Application No: A/164/21/AG
Site Address: Land south of Littlehampton Road Angmering BN12 6PN
Description of works: Notification under the Town & Country Planning (General Permitted Development)(England) Order 2015 under Schedule 2, Part 6, Class B(d) to upgrade existing agricultural track, providing access to Roundstone Farm.

Thank you for your internet representation made on 16th August 2021 which has been recorded as an objection with the comments as follows:

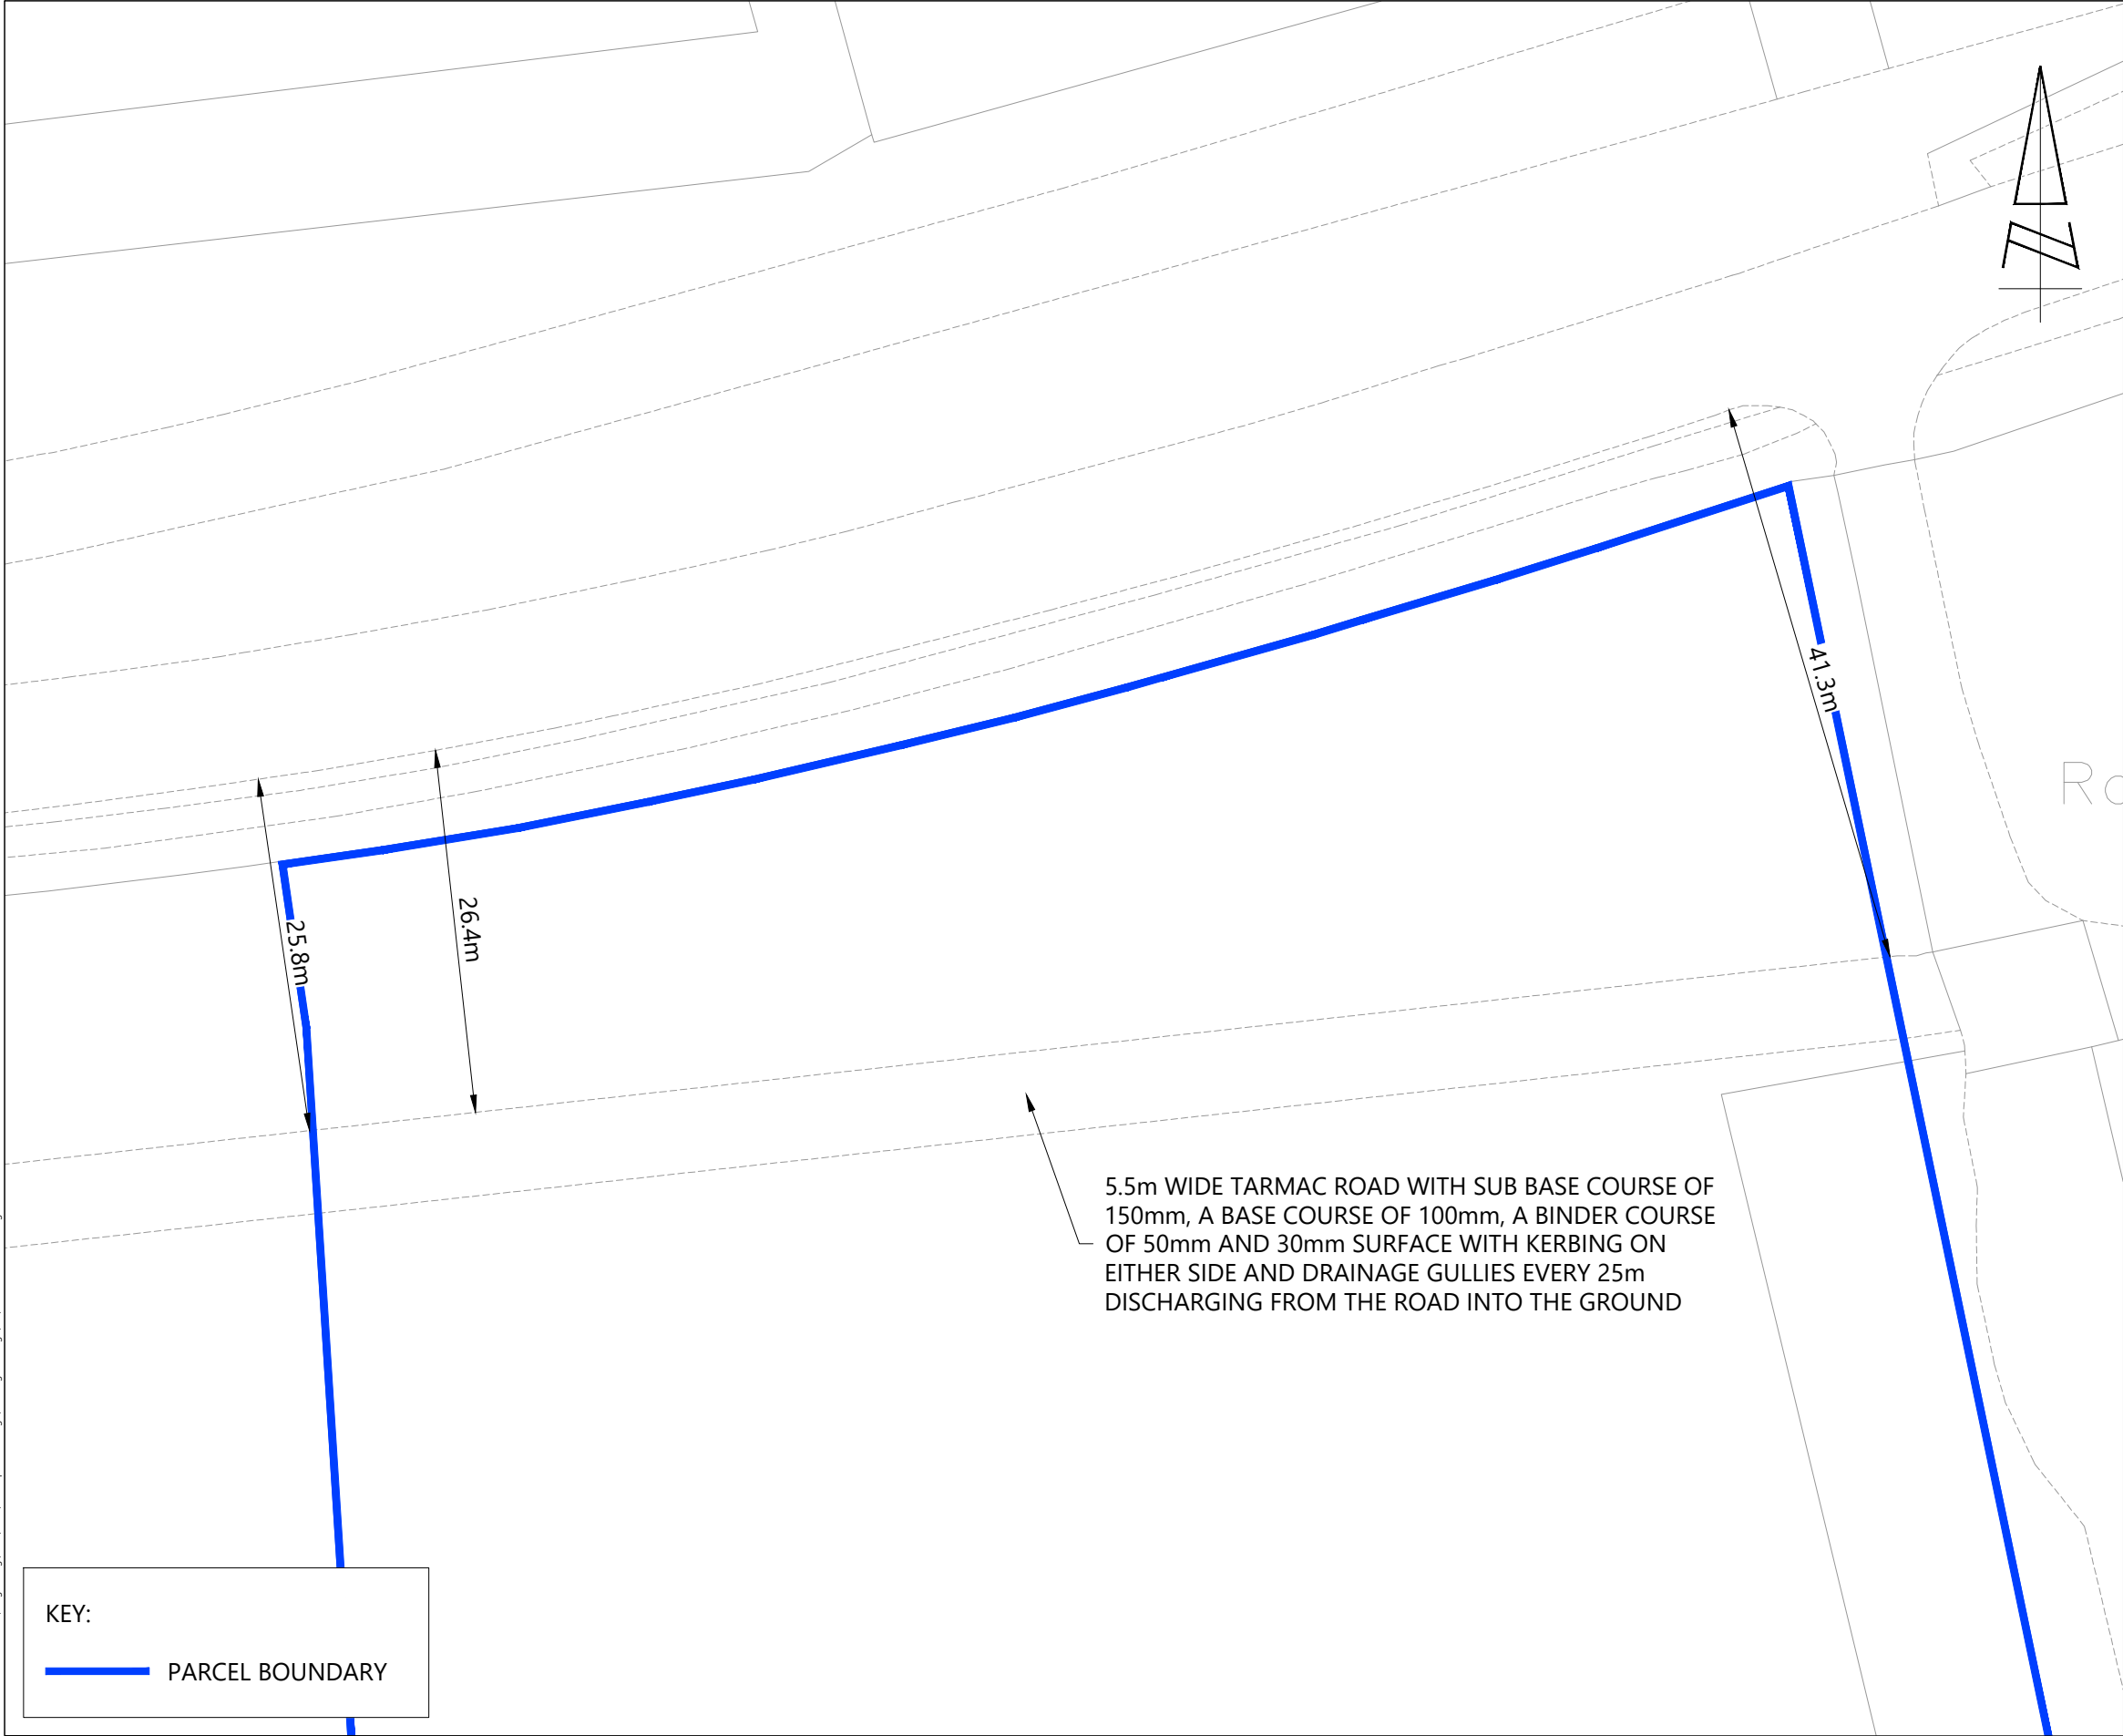
- Appearance - current road is adequate for farm vehicles to use as farm access. Tarmac roads are not a nice appearance in a green belt
- Traffic and Highway Safety- If this road were to be upgraded, this would increase the likelihood for the road to be used as a cut through so people can escape traffic which builds up on the roundabout. This is something that currently happens and is very dangerous but a better road surface would encourage this further. Maybe restricted use is needed? Or gated access? Adding to this, the highway footpath crosses the access which meets the roundabout. With increased traffic flow this will be a pedestrian Safety issue.

- Flooding - Increases in impermeable surfaces will adversely affect the fields and increase flooding. Infrequently used access tracks do not need to be this well maintained. The current road is more permeable and is the best surfacing for this level of usage.

- Scale and appearance of development - Currently, access can be met from the westbound a259 to the site and agricultural buildings. This means this road is likely to be infrequently used. The redeveloped road is wholly over scaled and overdevelopment that is necessary. Currently the site is in the green belt and I tarmac

surface seems inappropriate and will have an effect on the area.
- Design- the design is very over the top for just a agricultural road.
